Ku-ring-gai Council Submission

Major Project MP08_0244 –Environmental Assessment –
Mixed Use Development - 23-37 Lindfield Avenue and 11 Havilah
Avenue, Lindfield

December 2010

1 JUNE 21 -9AM
1:500

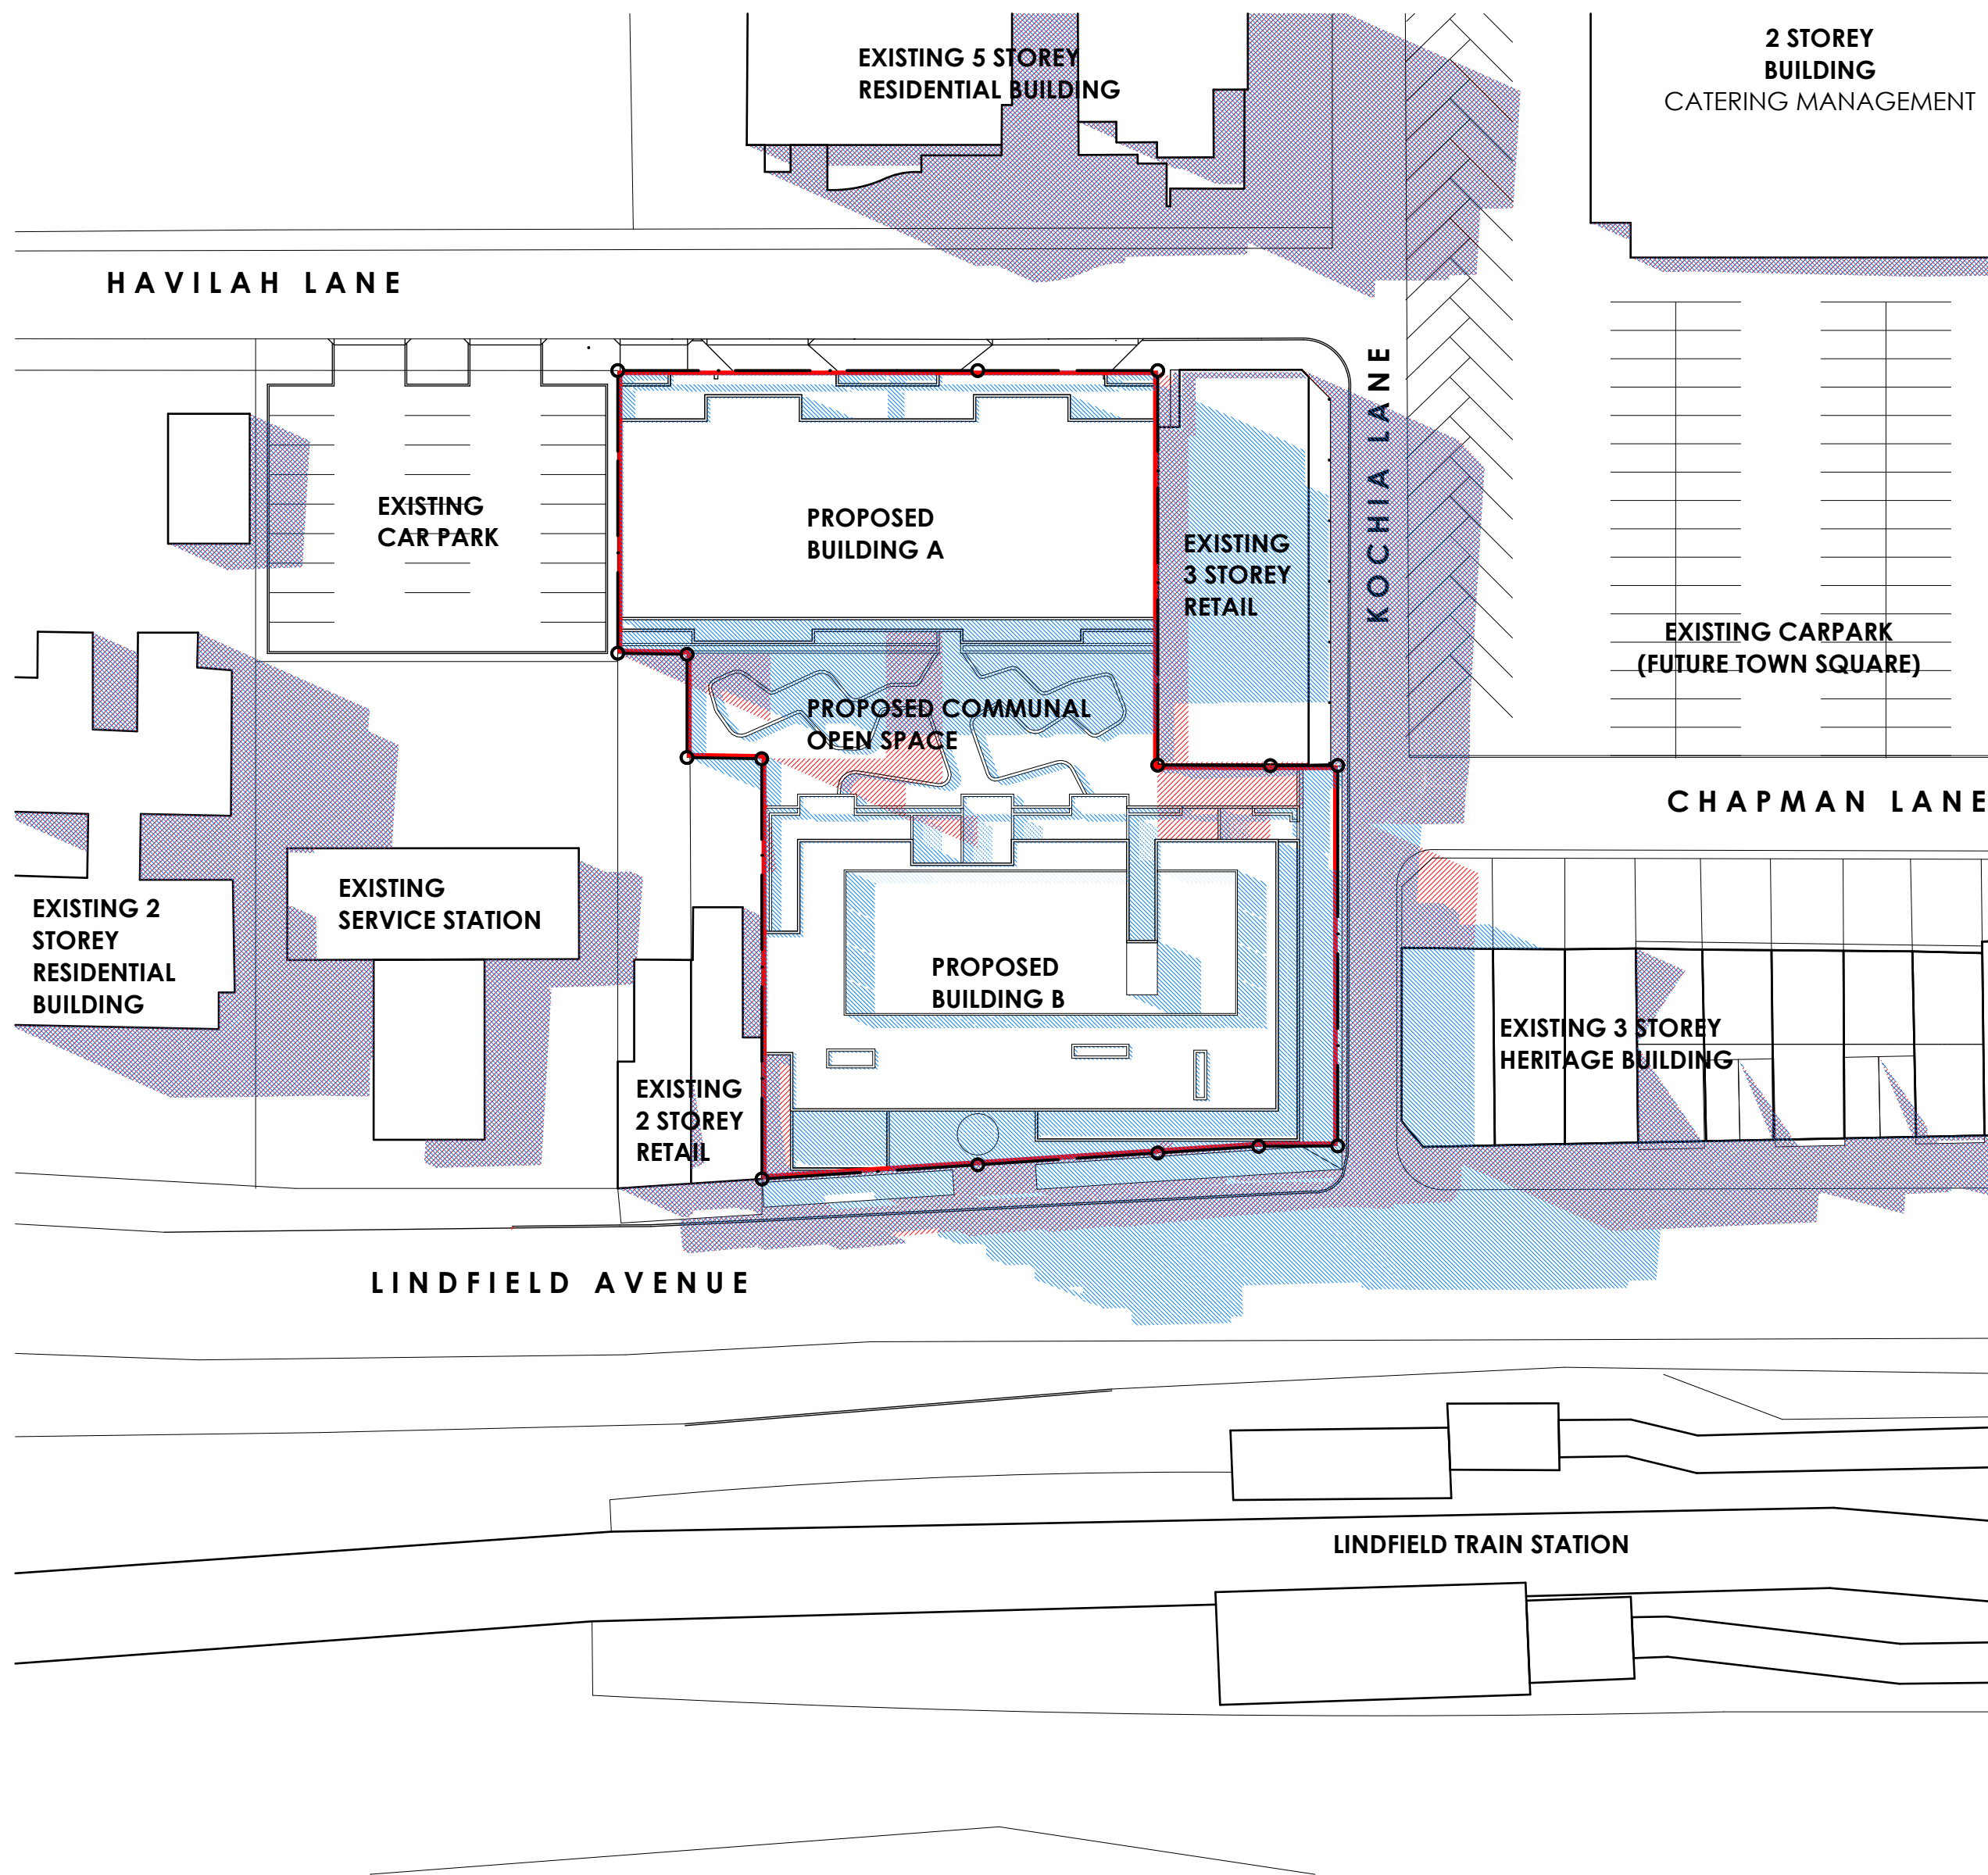
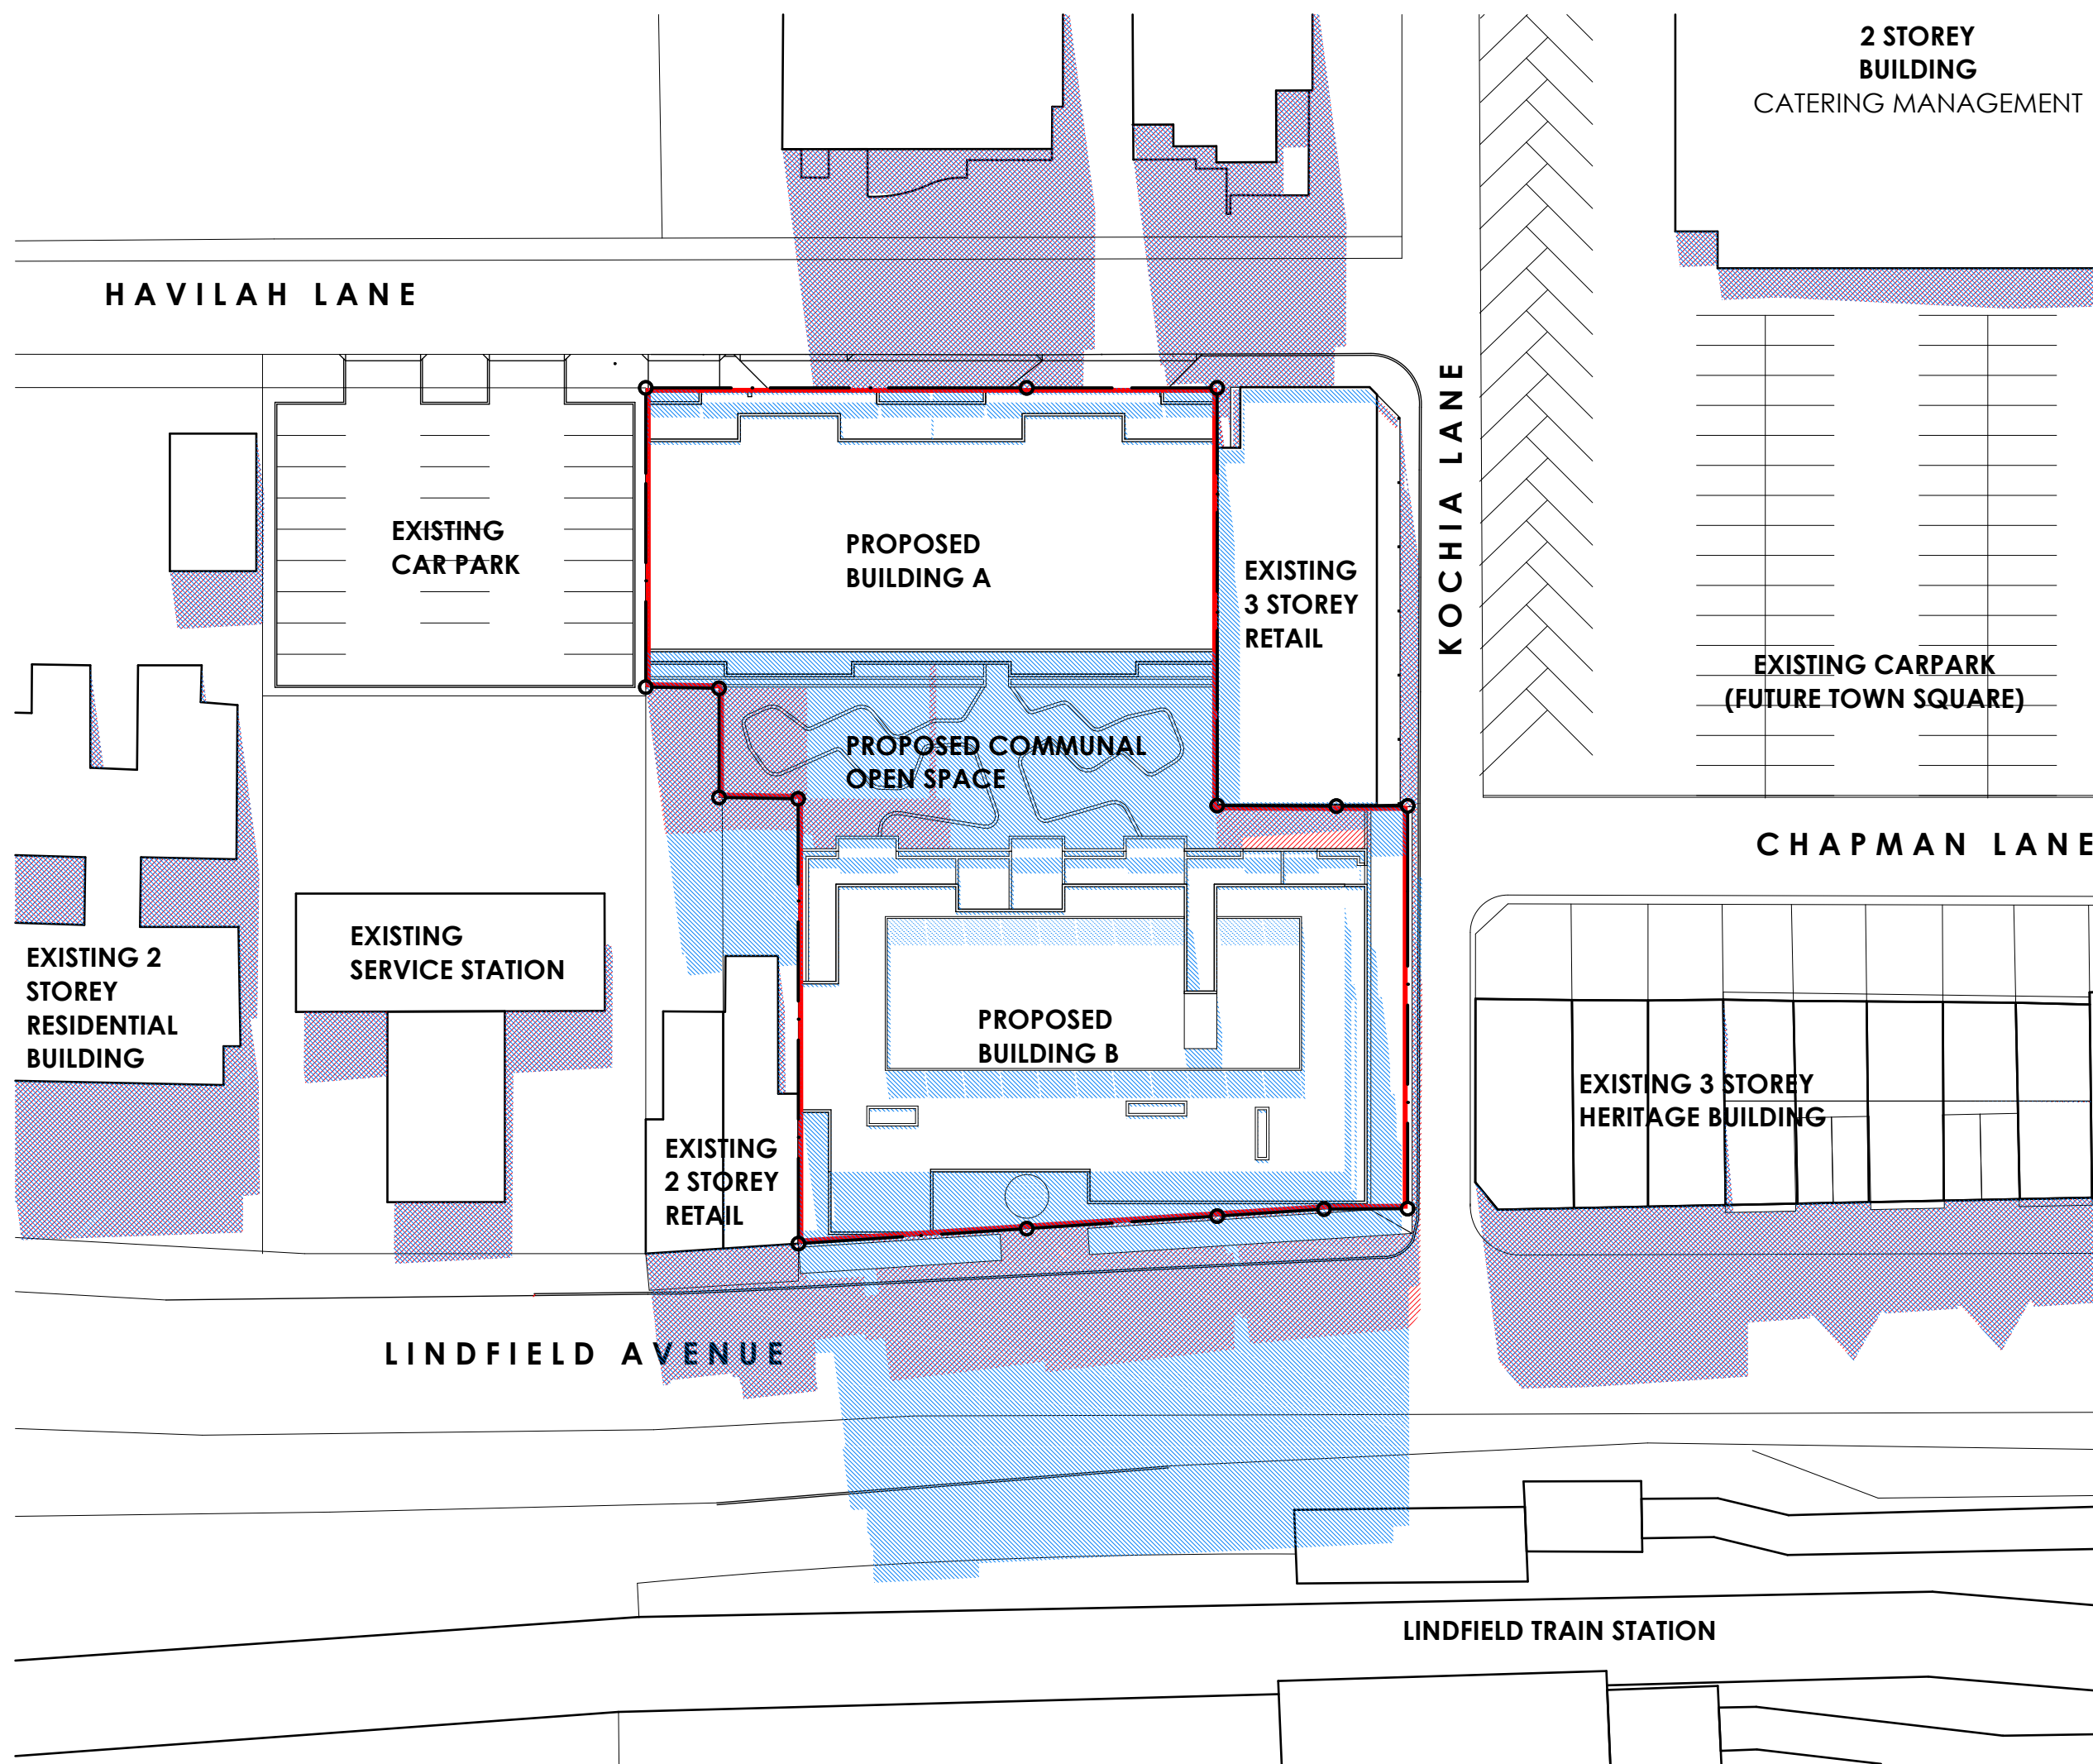
No solar access information was provided to assess compliance with SEPP 65. A report prepared by a suitably qualified person in this field is required. The report should include solar access diagrams/3d modelling addressing solar access requirements in the Residential Flat Design Code. The above report should specify the methodology of modelling, the date/time of the images, orientation of shadows cast and contain a compliance table demonstrating the performance of each individual unit referable to the solar access diagrams/3d modelling.

It is stated that the proposal does not comply with SEPP 65 in respect of solar access due to the fact that the development is located in a town centre. This is not considered adequate justification. A vastly improved outcome can be achieved through redesign as the bulk of the overshadowing is by the development itself (Block A to Block B). The inappropriate use of blade walls also significantly reduces solar access.
